Caitlin Cameron - Re: 16 middle and 185 fore street

From: Jeff Tarling
To: Caitlin Cameron
Date: 7/1/2014 1:43 PM
Subject: Re: 16 middle and 185 fore street
CC: David Margolis-Pineo

PROJECT	185 FORE STREET PORTLAND, MAINE
SHEET TITLE	SITE LAYOUT PLAN
CLIENT	BATEMAN PARTNERS LLC

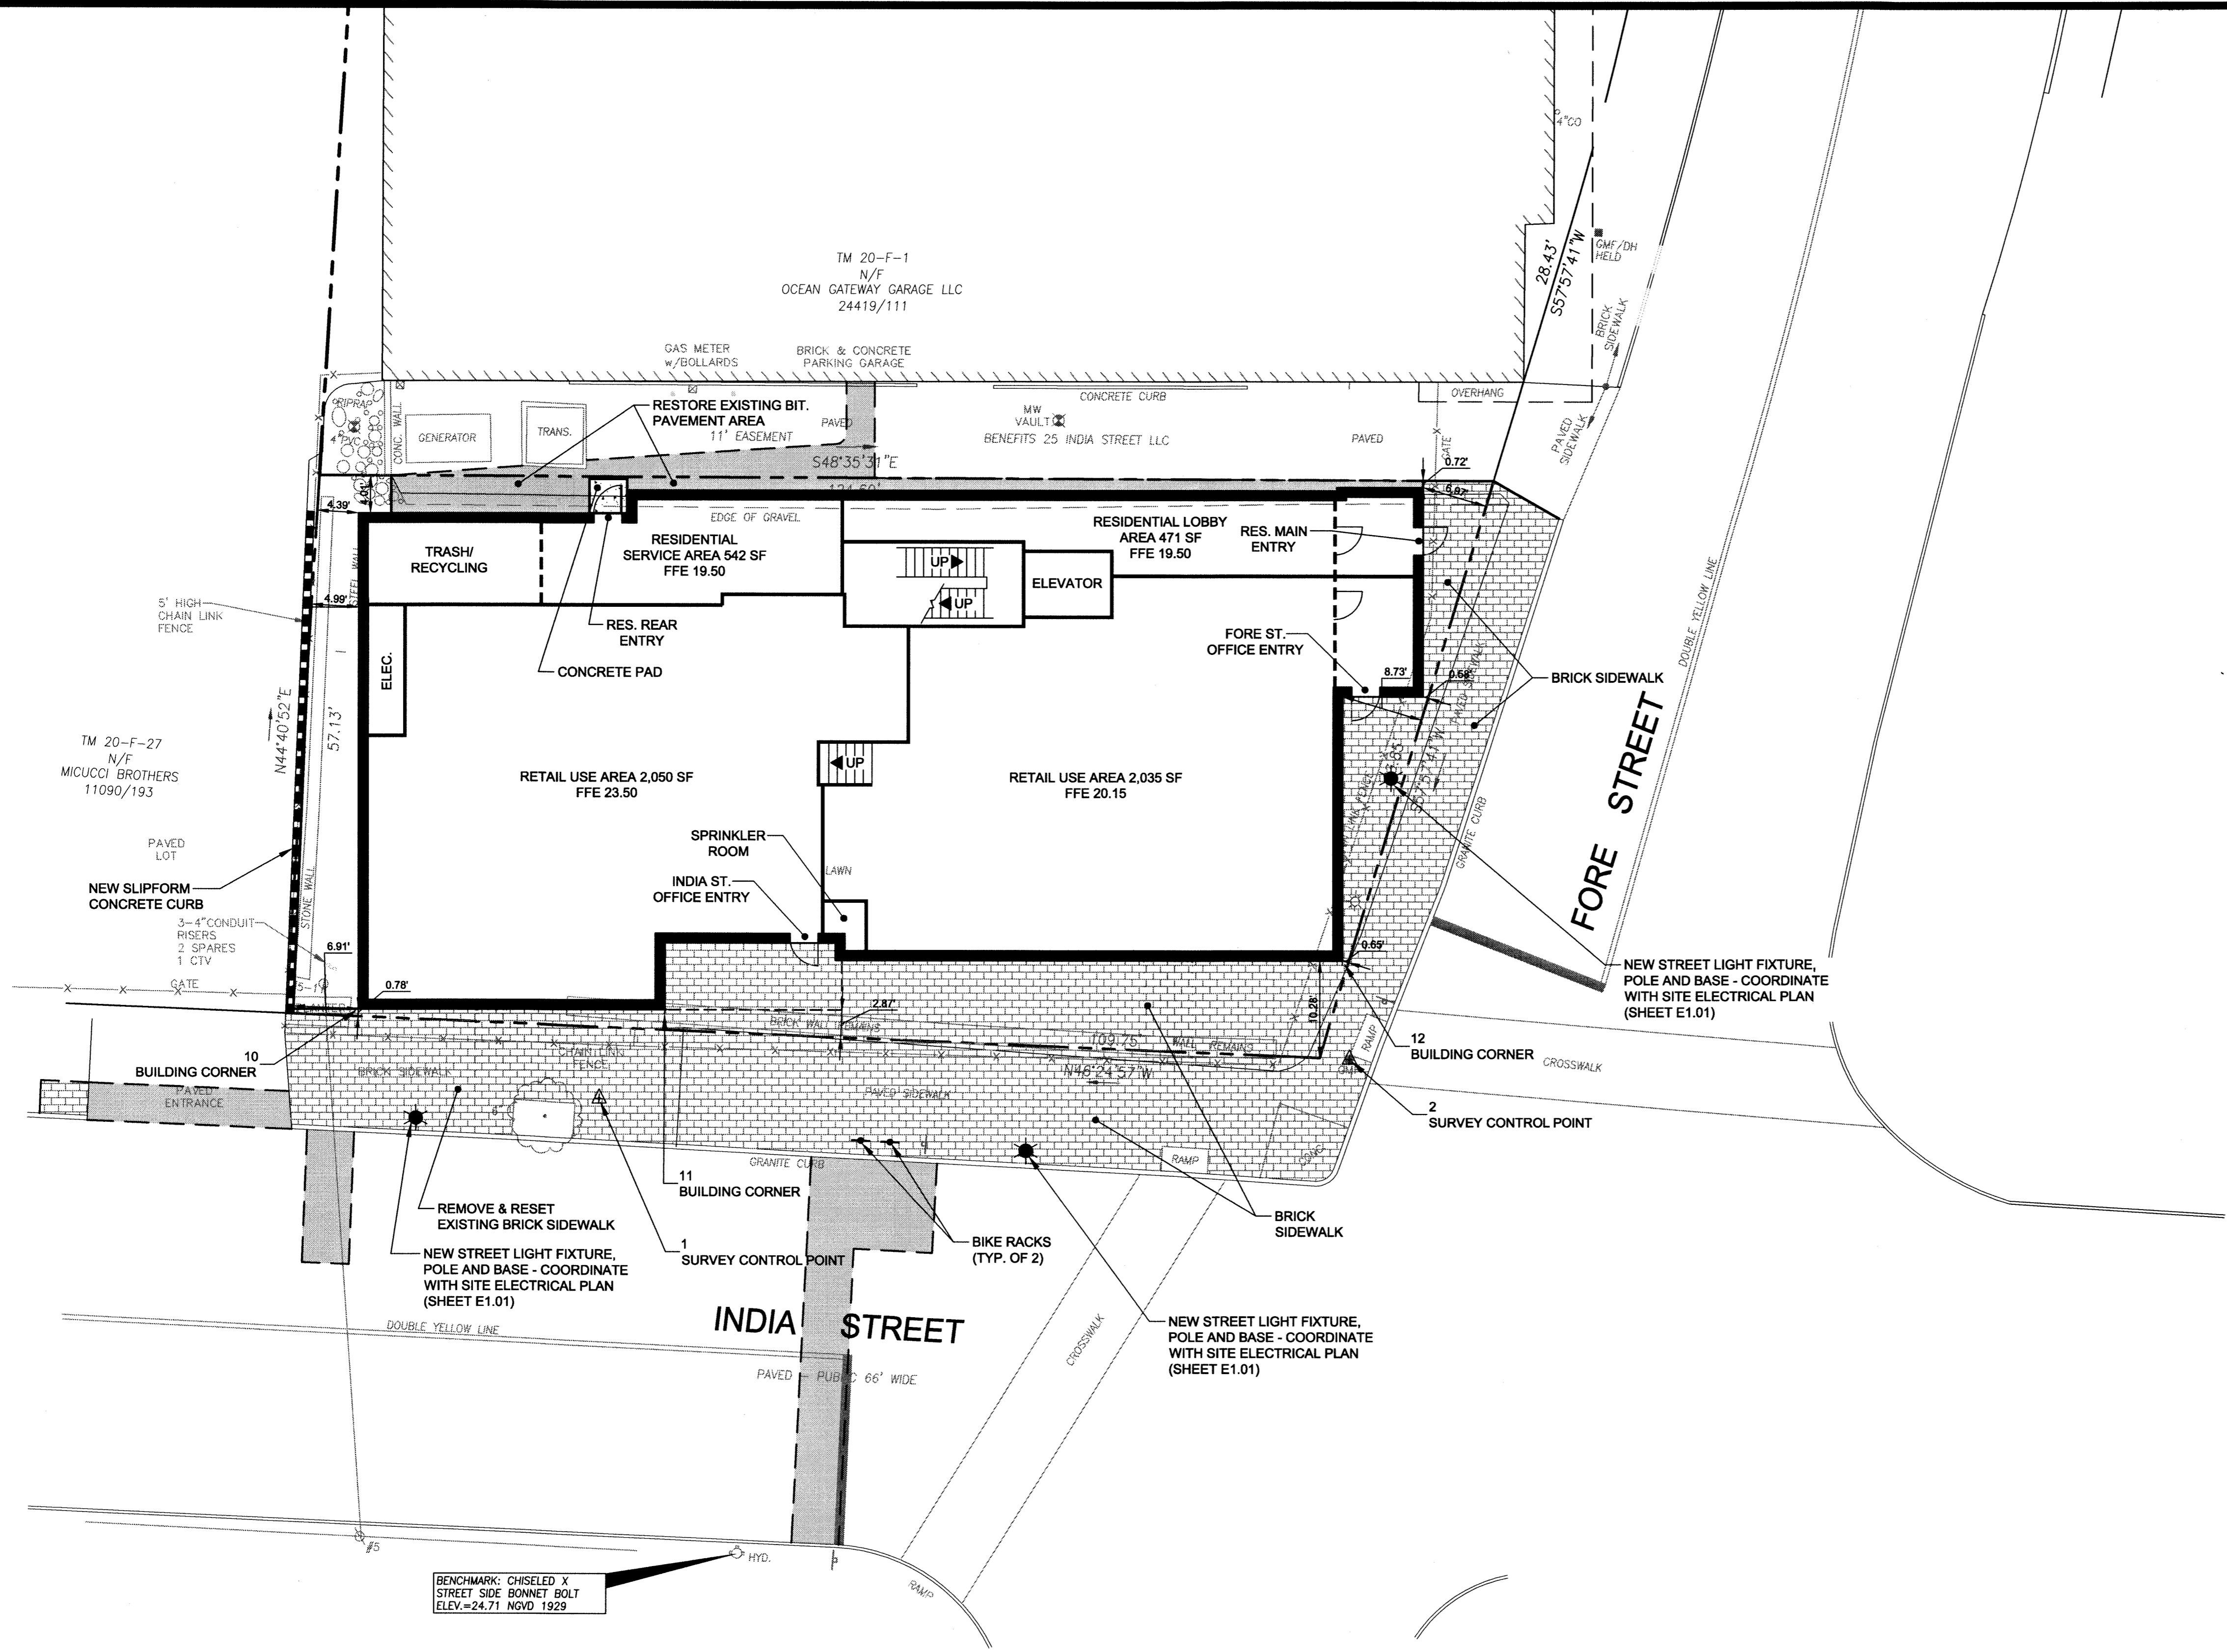
This plan adds needed green landscape element into the street-scape. The only question is on India Street @ Fore Street the closest tree pit to Fore Street, is there adequate clearance for pedestrians between the street tree and new planter?
